CITY OF ALBUQUERQUE

July 17, 2017

**RE: The Cage
Grading and Drainage Plan
Stamp Date: 7/12/17
Hydrology File: K17D114**

Based upon the information provided in your submittal received 7/12/17, the Grading and Drainage Plan **is not** approved for Building Permit. The following comments need to be addressed for approval of the above referenced project:

A1 GRADING and DRAINAGE PLAN

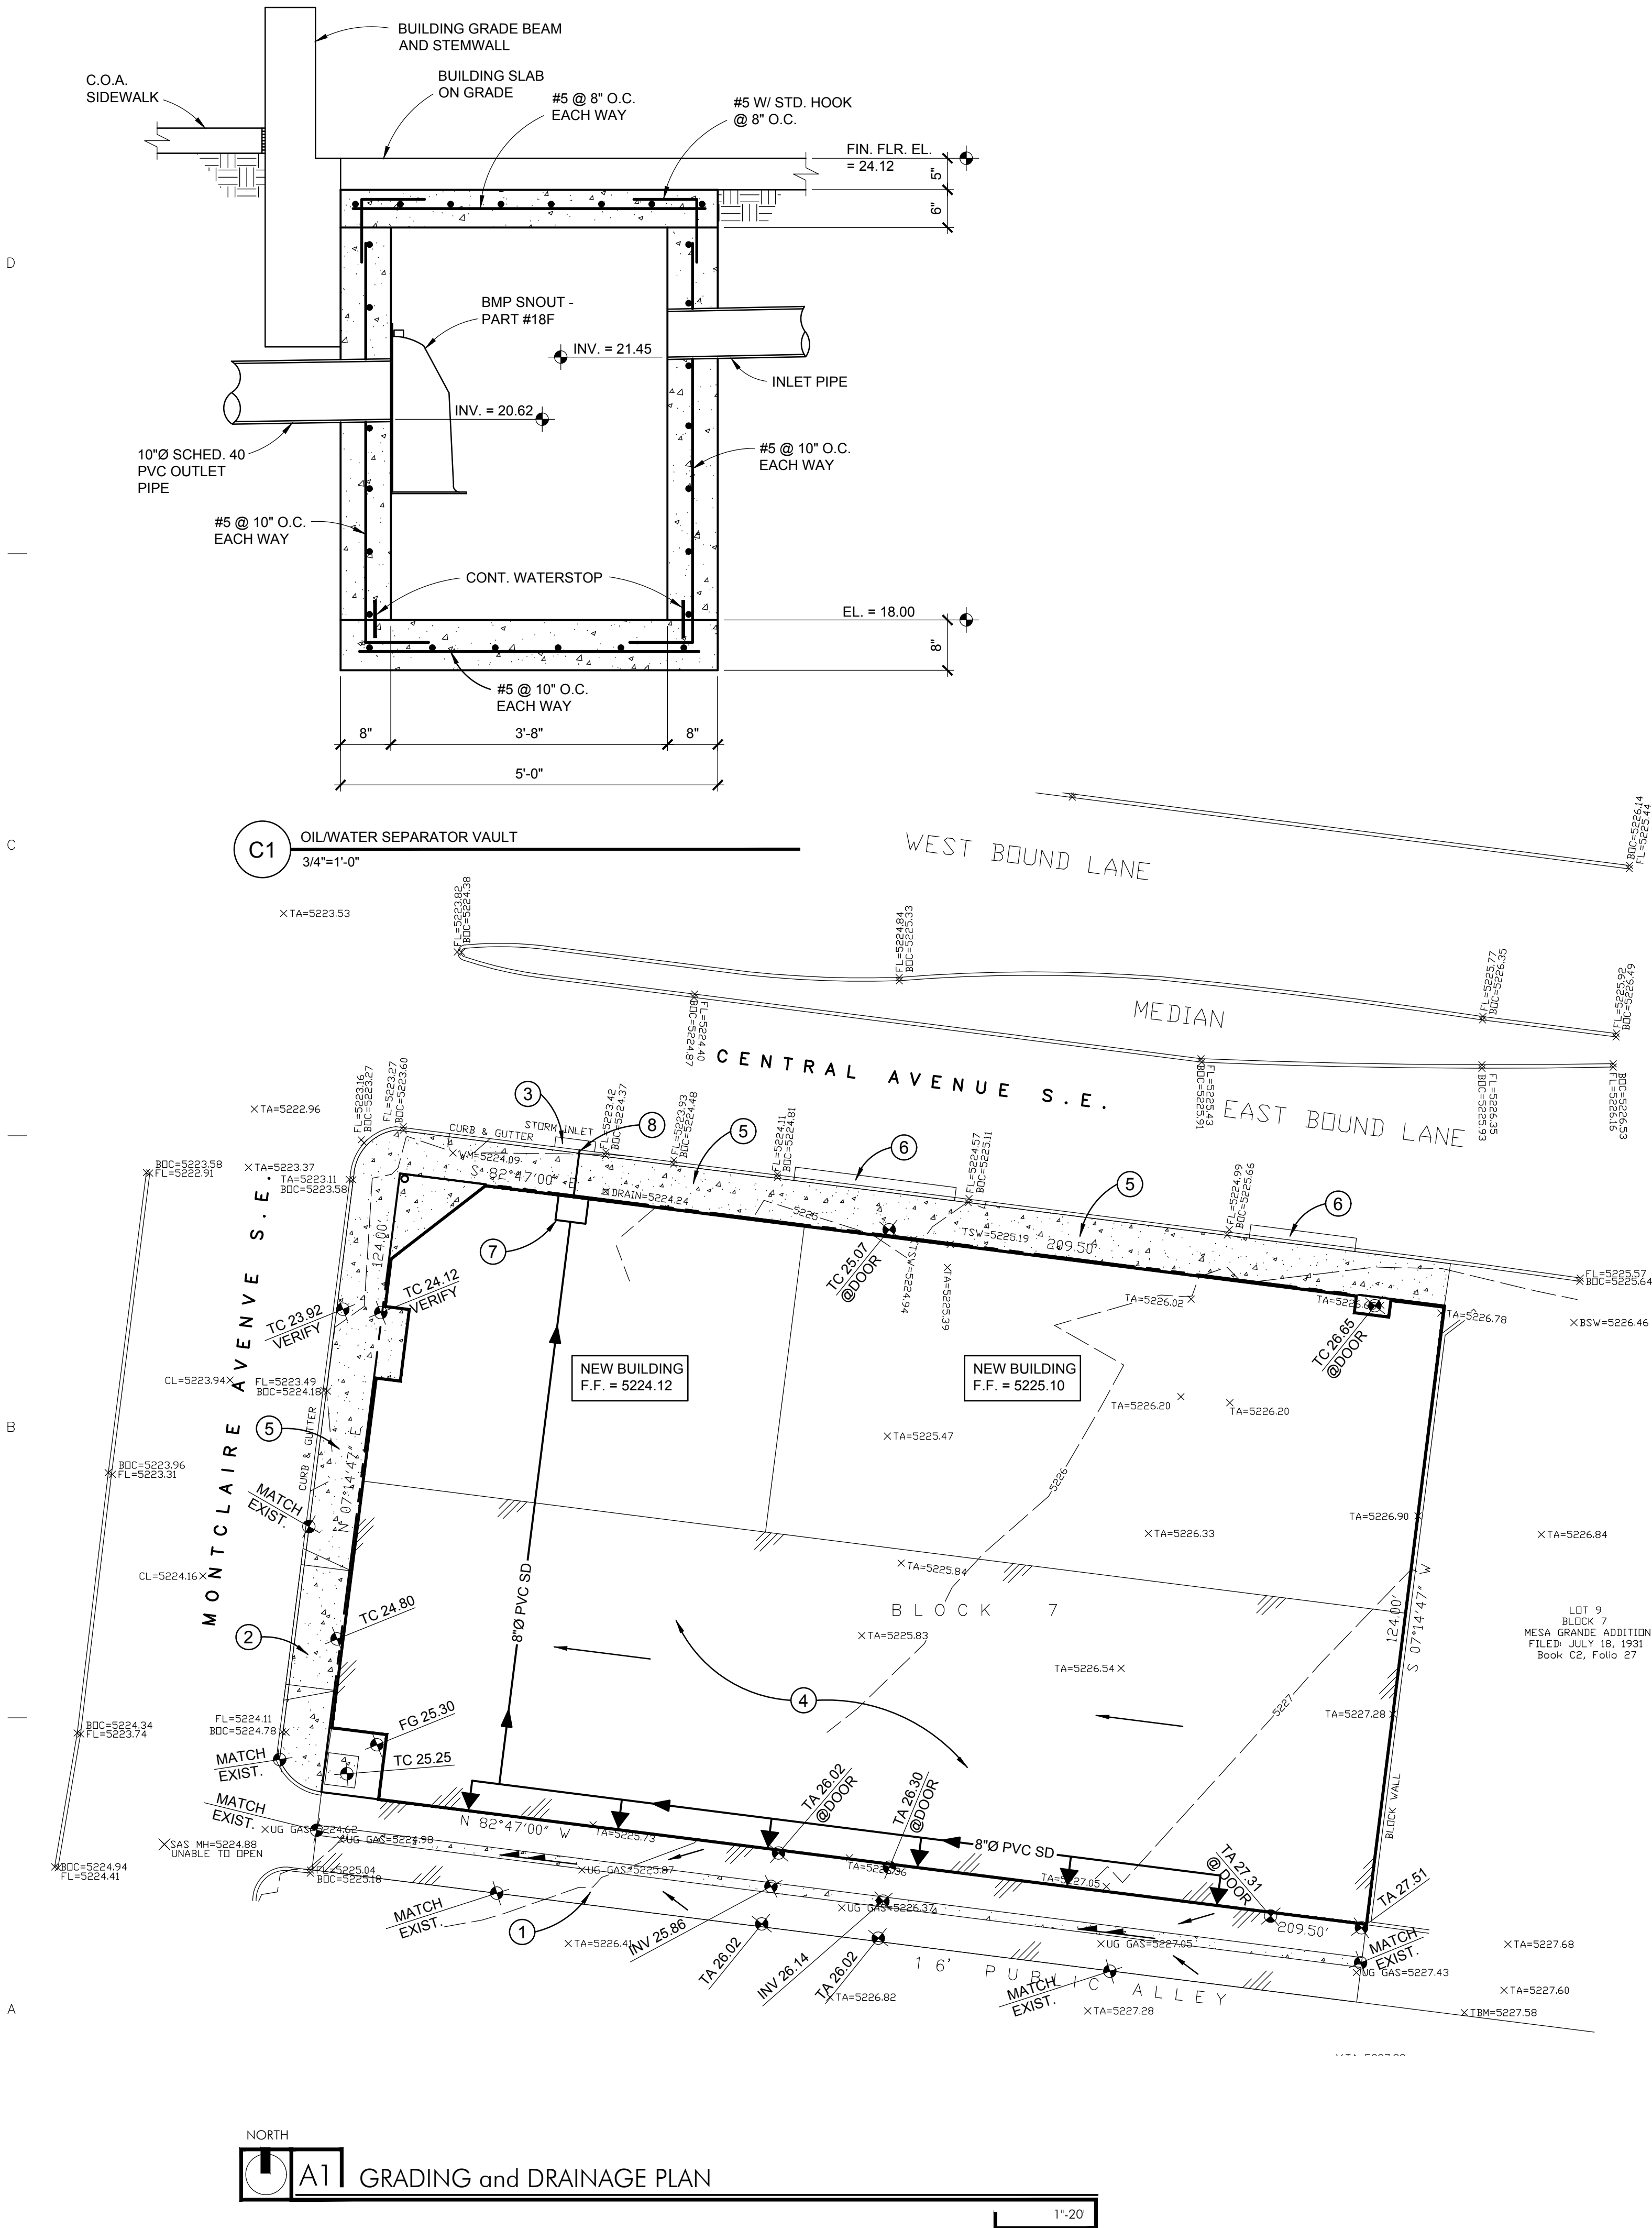
1. The storm water quality volume for this site is required in order to manage the storm water runoff. Since this is a redevelopment site, the storm water quality volume is calculated based on the 0.48 inch storm. To calculate the required storm water quality volume to be captured, multiply the impervious area by 0.28 inches for the 80th percentile storm.
